RE: Utility Encroachment

**Project Location: 9440 Bur Oak Ln – Lot 8 Cottonwood Meadows Filing 3:**

9440 Bur Oak Ln - Site Plan

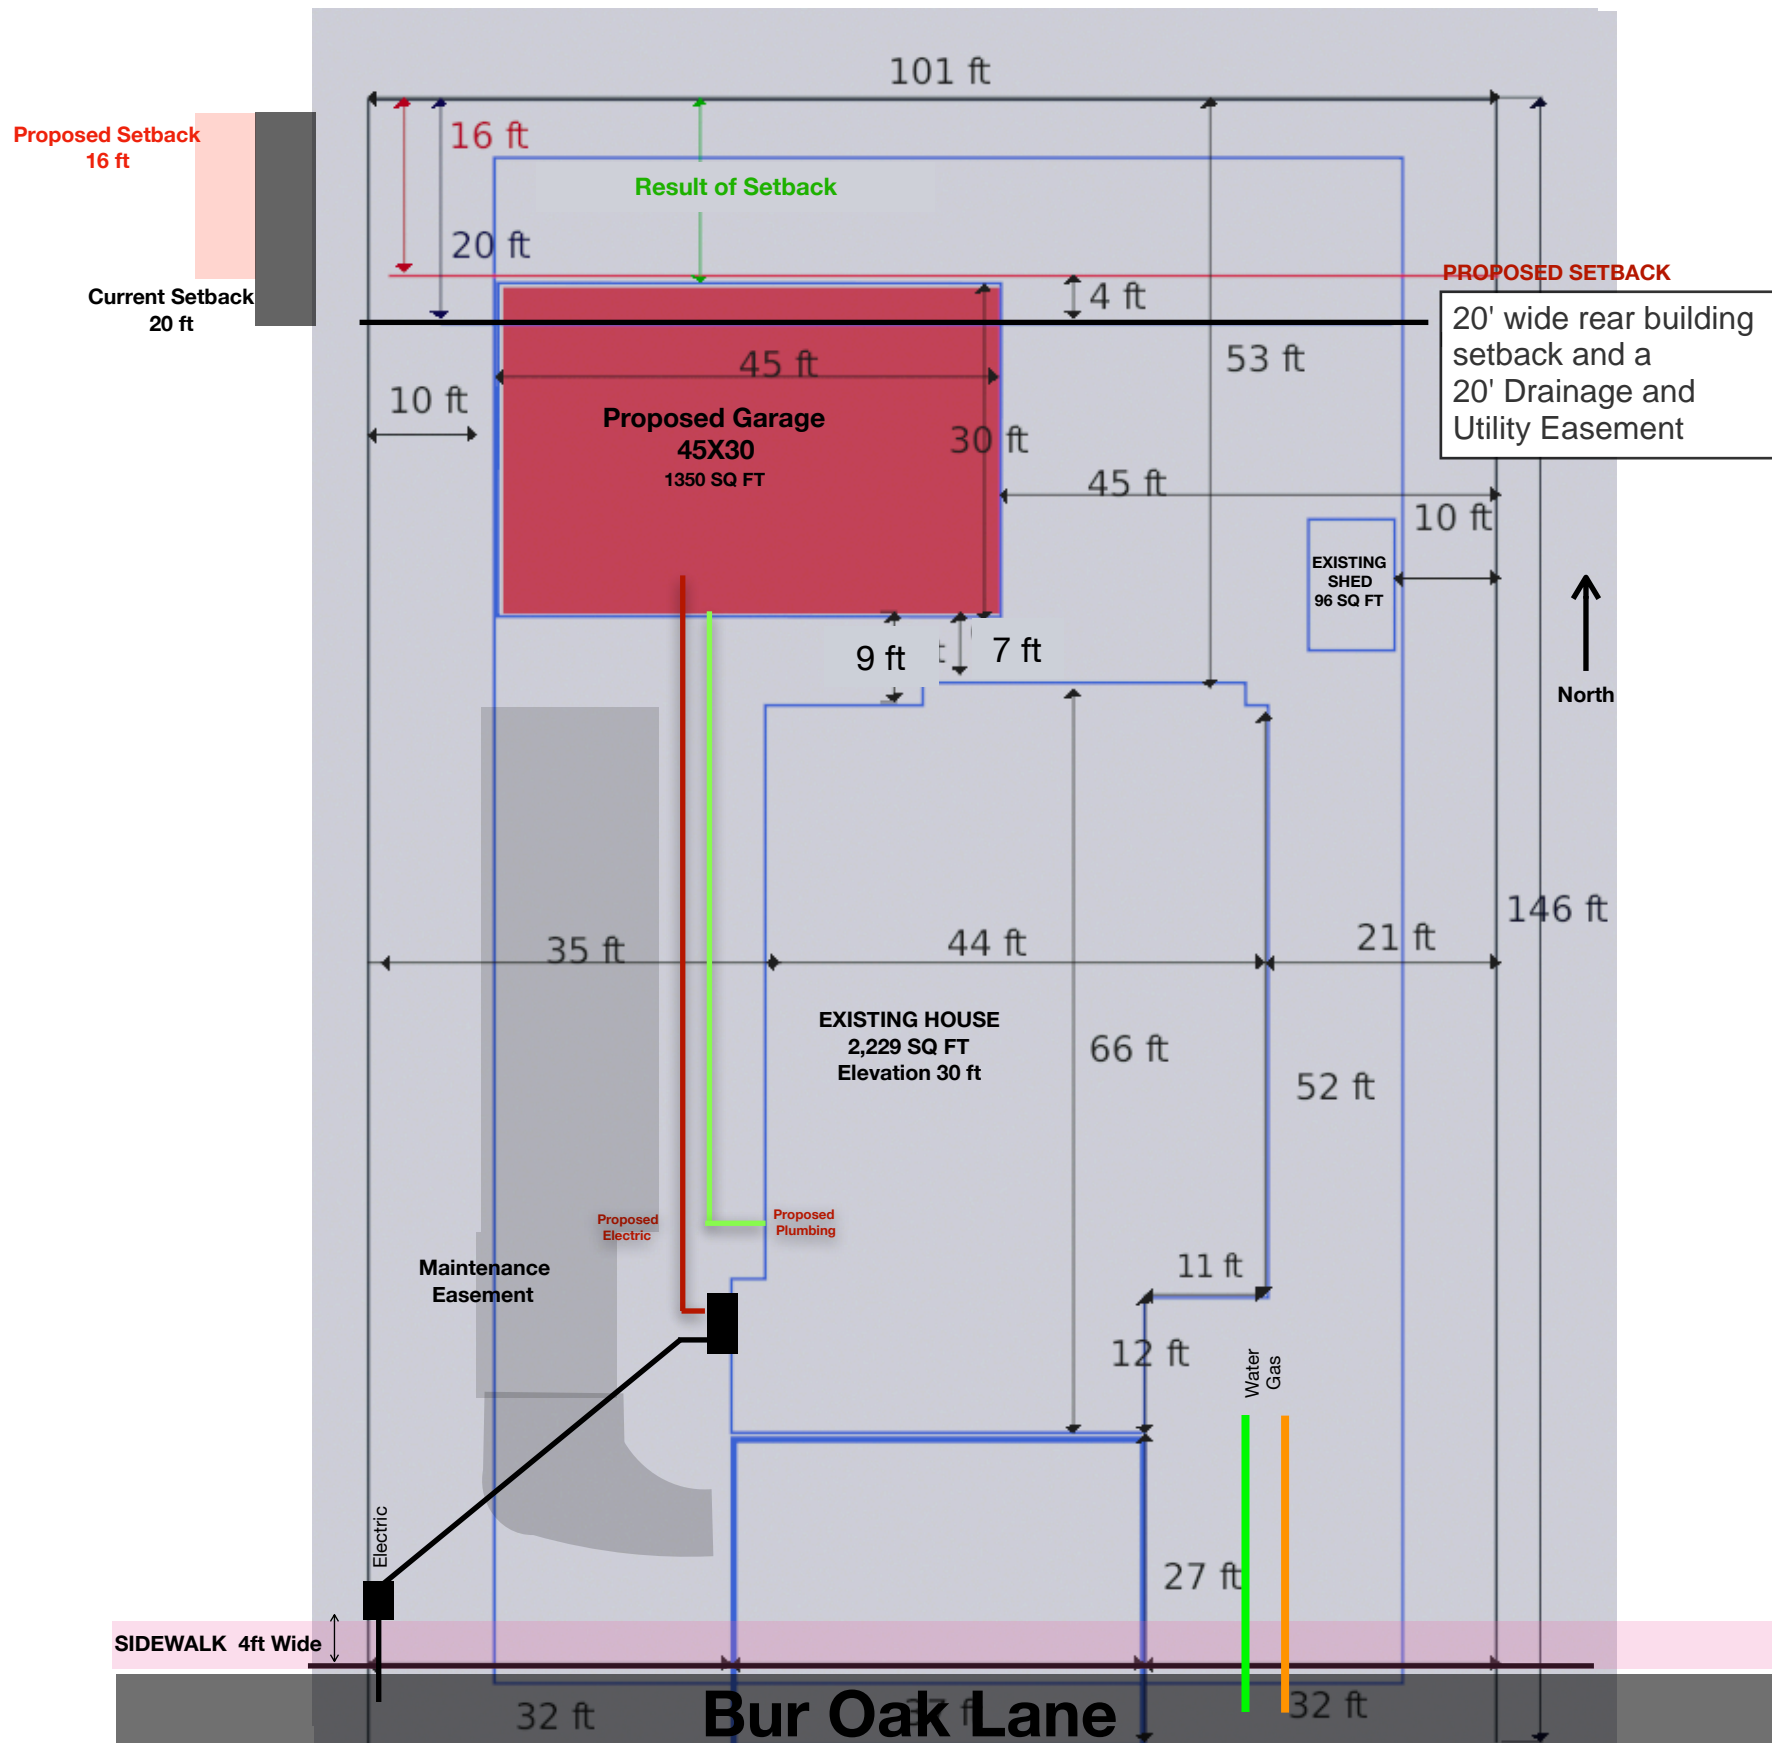
The Association requests that the 10-feet of the platted 20-foot rear easement adjacent to the rear lot line remain unencumbered. The Association has no objection to the encroachment of the additional 10-foot portion of the rear lot line utility easement.
